Letter No. B3/22089/2004

Sub: CMDA - Area Plans Unit - Planning permission  
- Proposed construction of Two Blocks of Stilt  
+ 4Floors - Residential building with 27 dwelling  
units at Departmental store -142m<sup>2</sup> plot No.1,  
2,3,4, & 5 and Shop site in R.S.No.241/5,6 & 7  
of Nolasbar Village - Villivakkam Panchayat  
Union - Remittance - ~~Requesting~~ Development Charge  
and other<sup>e</sup> Charges - Requested - Regarding.

STILT PLAN & GROUND FLOOR PLAN

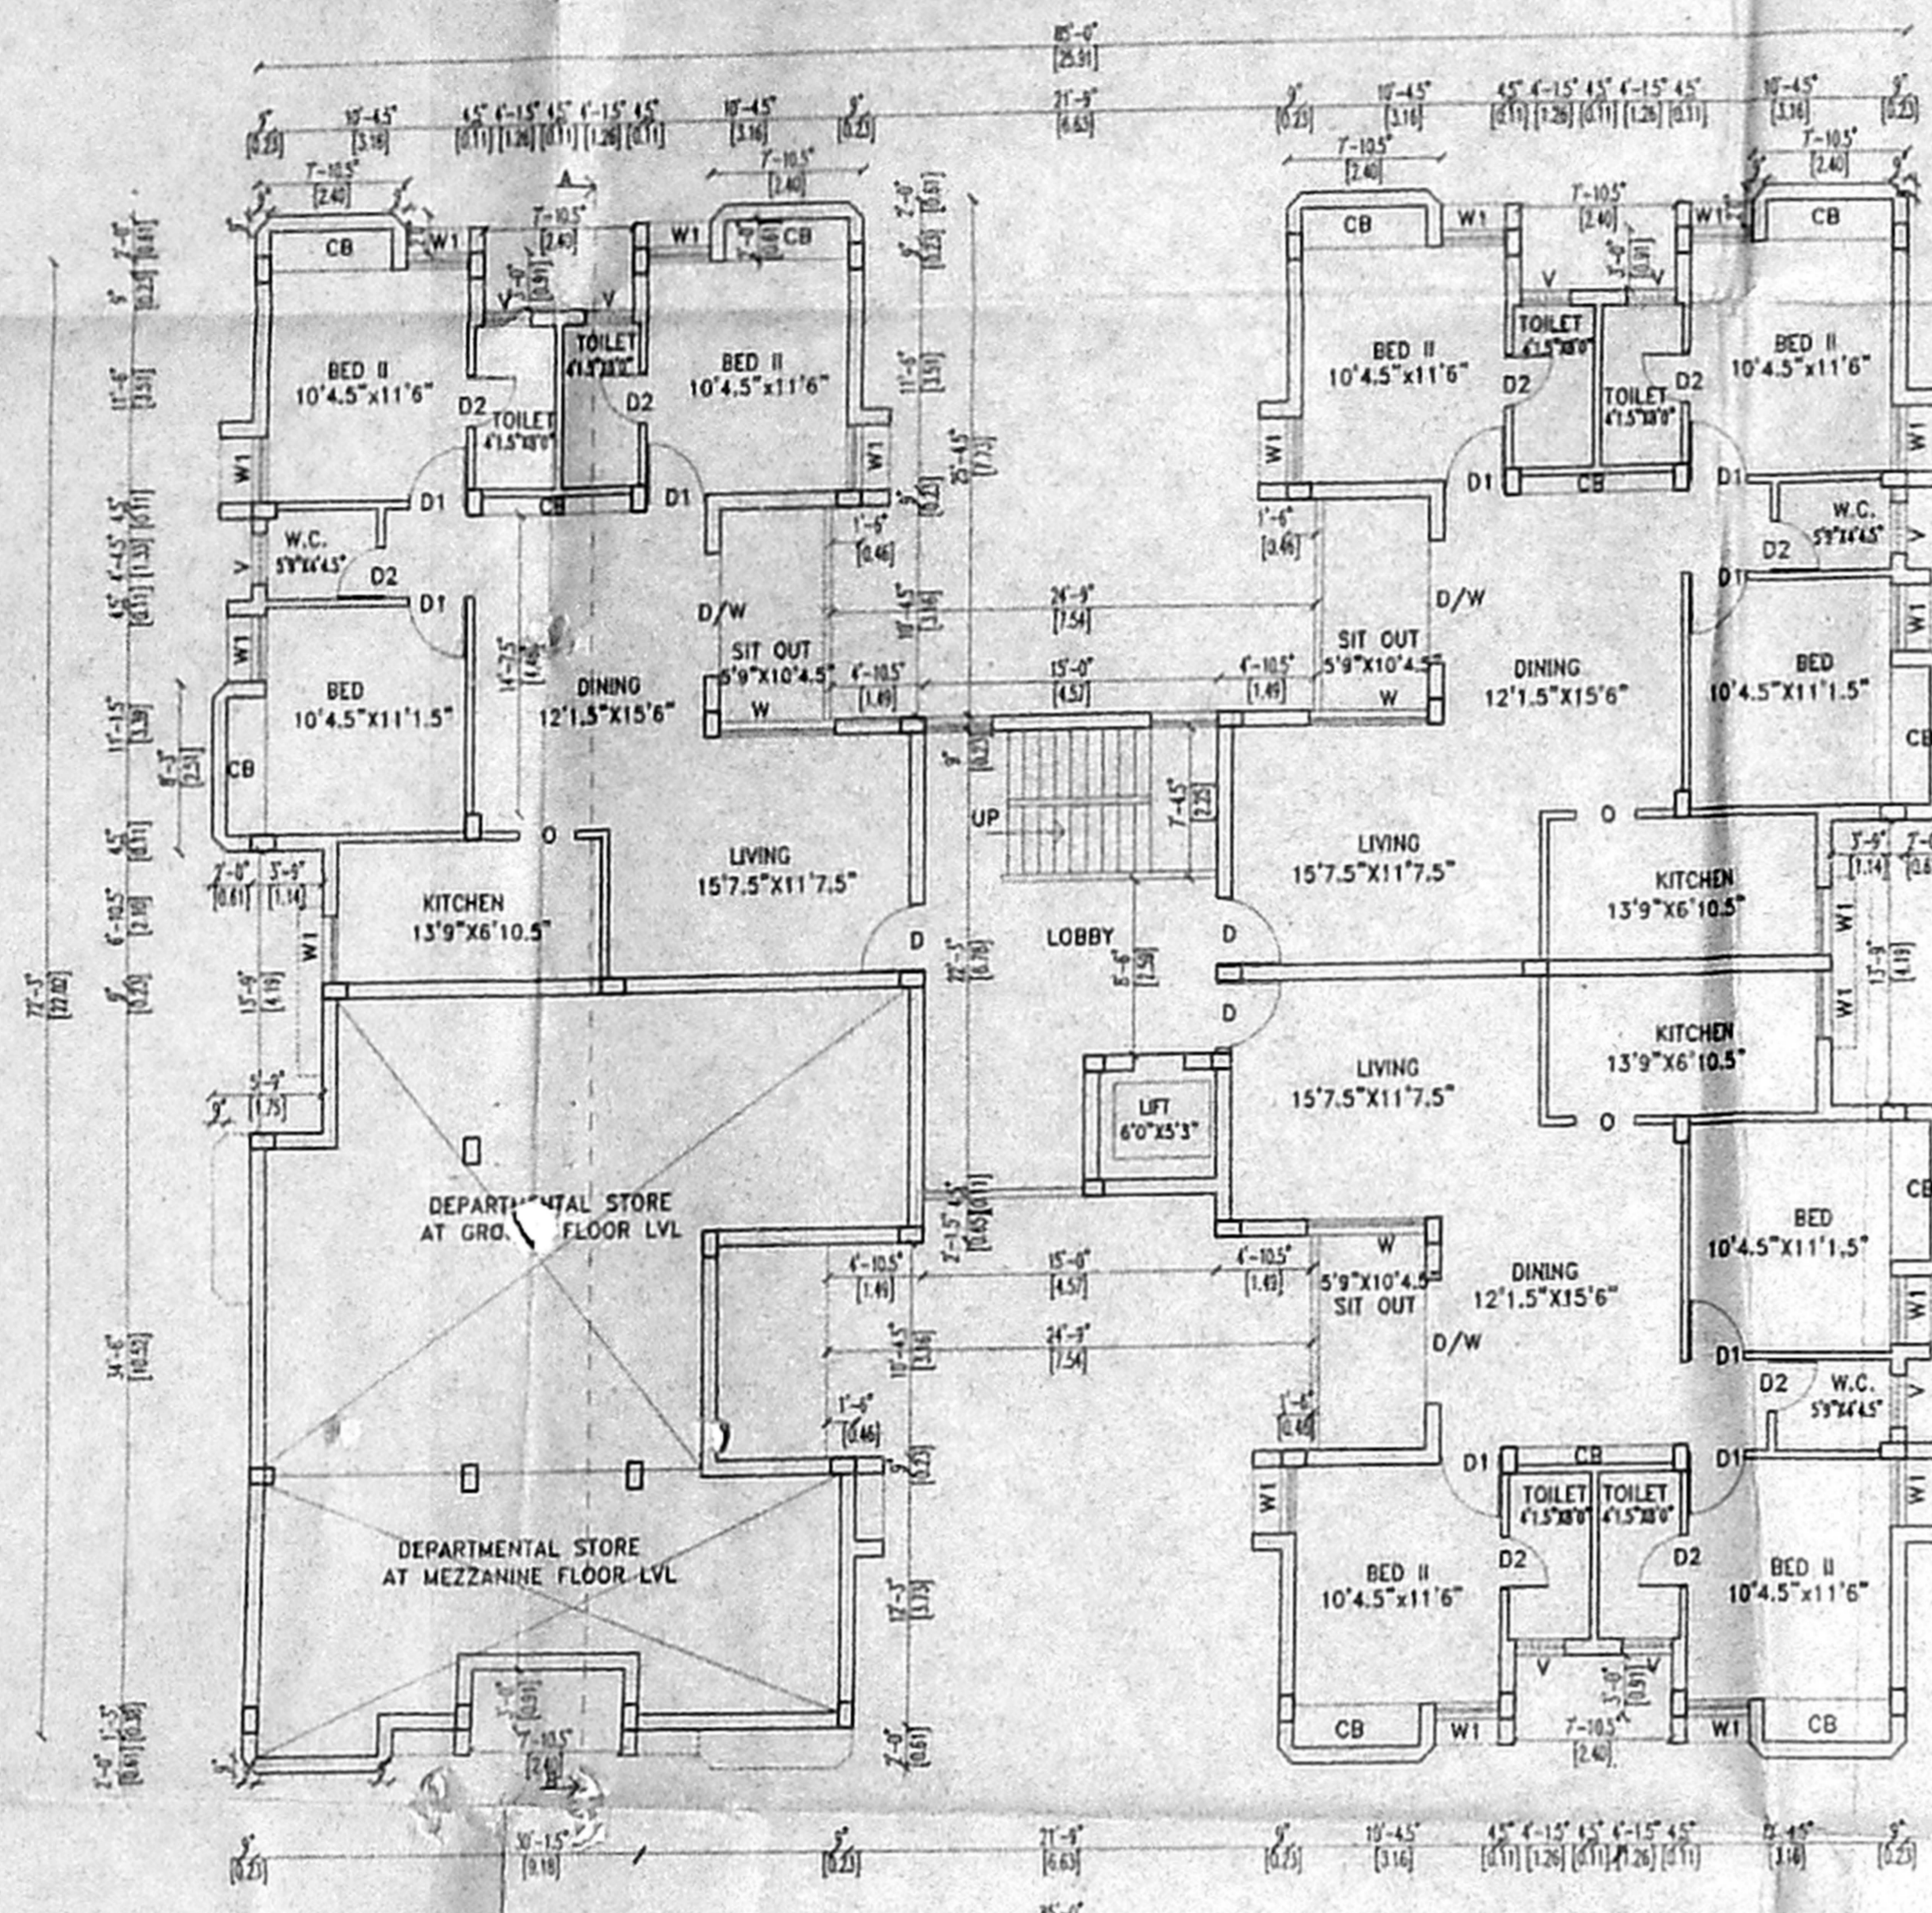
- a) 5 Copies of Revised plan rectifying the following defects:
  - i) GF & MF - Departmental Store which is available in lower level should be shown in dotted line a First Floor detailed floor plan.
  - ii) side walls at GF adjacent to the Lift ~~and~~ <sup>and</sup> staircase to be deleted and also the word Lobby in GF to be deleted.
- b) Under taking in Rs.20/- stamp paper stating that the septic tank with upflow filter desig<sup>gn</sup> to the site under reference as per approved plan will be construction and maintained properly until the same is handed to the flat owner<sup>s</sup> ~~and~~ <sup>associated in</sup> future.
